MEMORANDUM

Date: 21 June 2017
To: Georges River Council
Attention: Rita Vella, Coordinator – Strategic Planning
Subject: Penshurst Public School
Proposed redevelopment

James Stephany
Georges River Heritage Advisor

PERUMAL PEDAVOLI ARCHITECTS
PENSHURST PUBLIC SCHOOL
 18 Arcadia Street, Penhurst
 DRAWING NAME
DEMOLITION PLAN

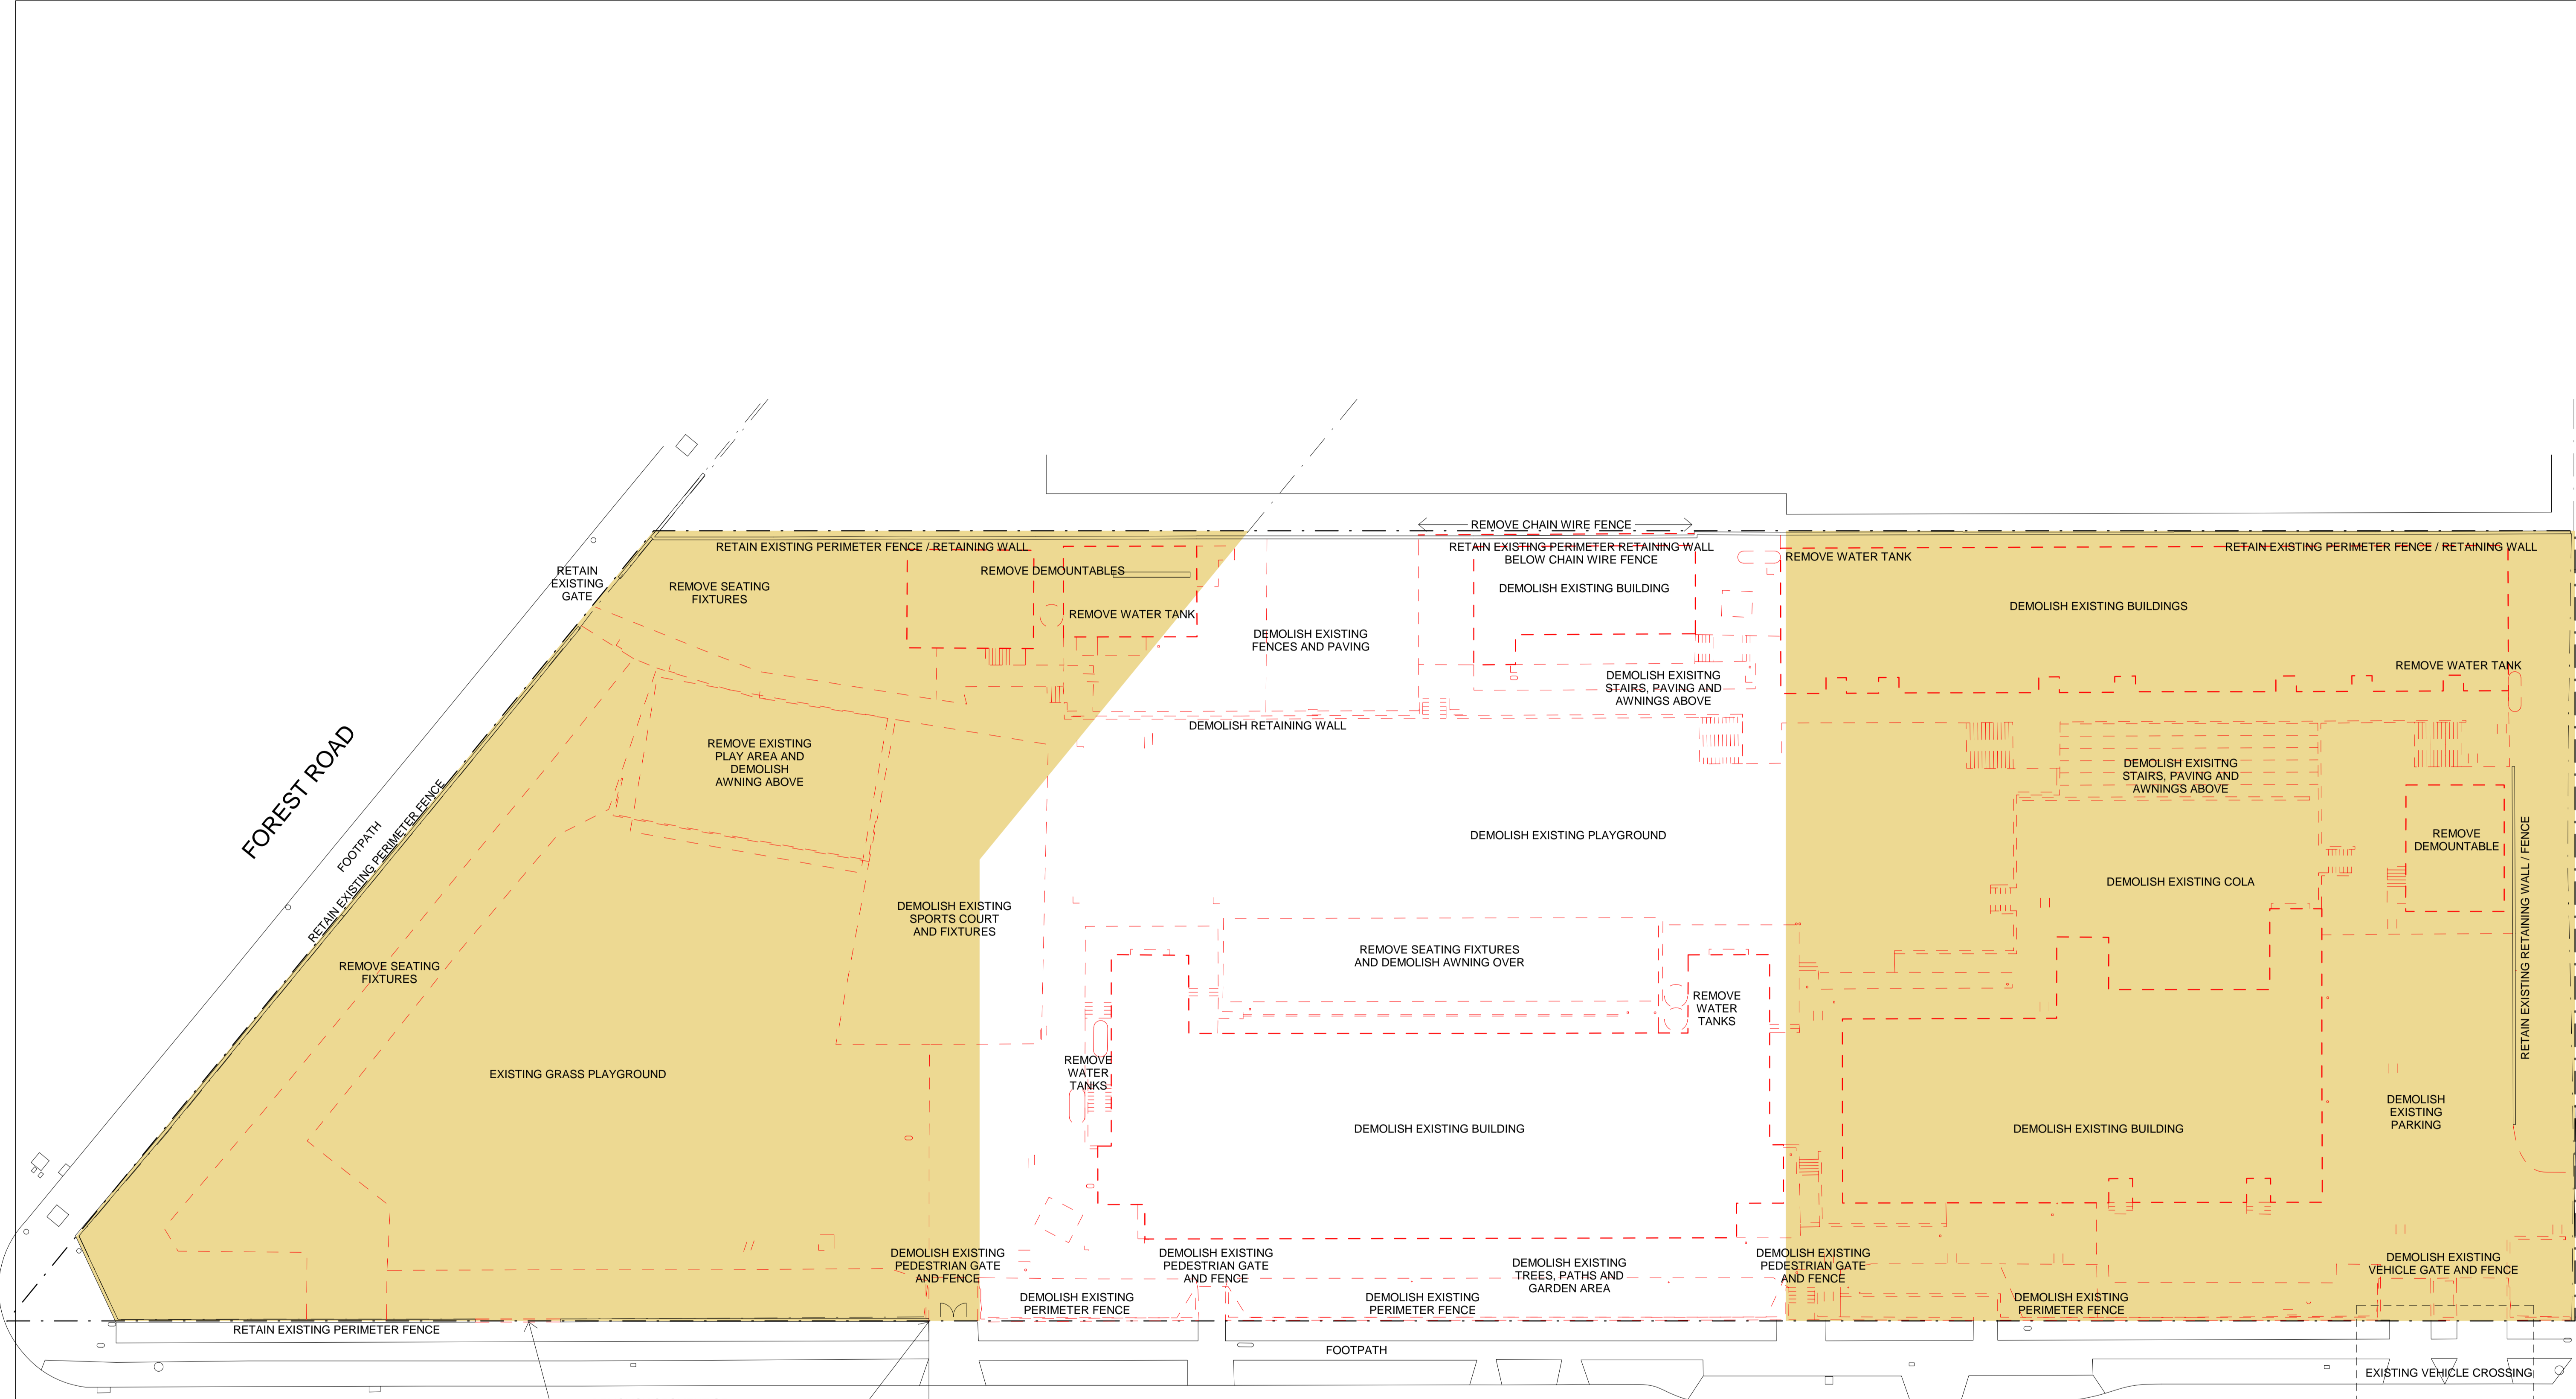
- 2) The letter from dfp Planning Consultants notes that of the various options considered for the redevelopment of the subject site, demolition of the heritage item is recommended by the Department of Education. Detailed justification for the above decision has not been provided in the documents reviewed.
- 3) The SoHI provides comparable analysis of other public schools in the Georges River Council area. From the above it can be confirmed that:

Based on a review of the documents provided, there is no support for the demolition of the subject heritage item (including the early two-storey addition) from a heritage point of view. To gain potential support the following additional information is required:

- i) Credible justification from a community benefit point of view by the Education Department as to why the heritage item (and early addition) cannot form part of the redevelopment of the site.
- ii) Further comparable analysis in the SoHI to:
 - confirm (or otherwise) that Peakhurst Public School (or any other Inter-War P.S. in the Georges River LGA) displays equal or superior Inter-War Free Classical stylistic influence to the subject heritage item, and;
 - that there are other institutional buildings in the Georges River LGA with equal or superior Inter-War Free Classical stylistic influence to the subject heritage item.
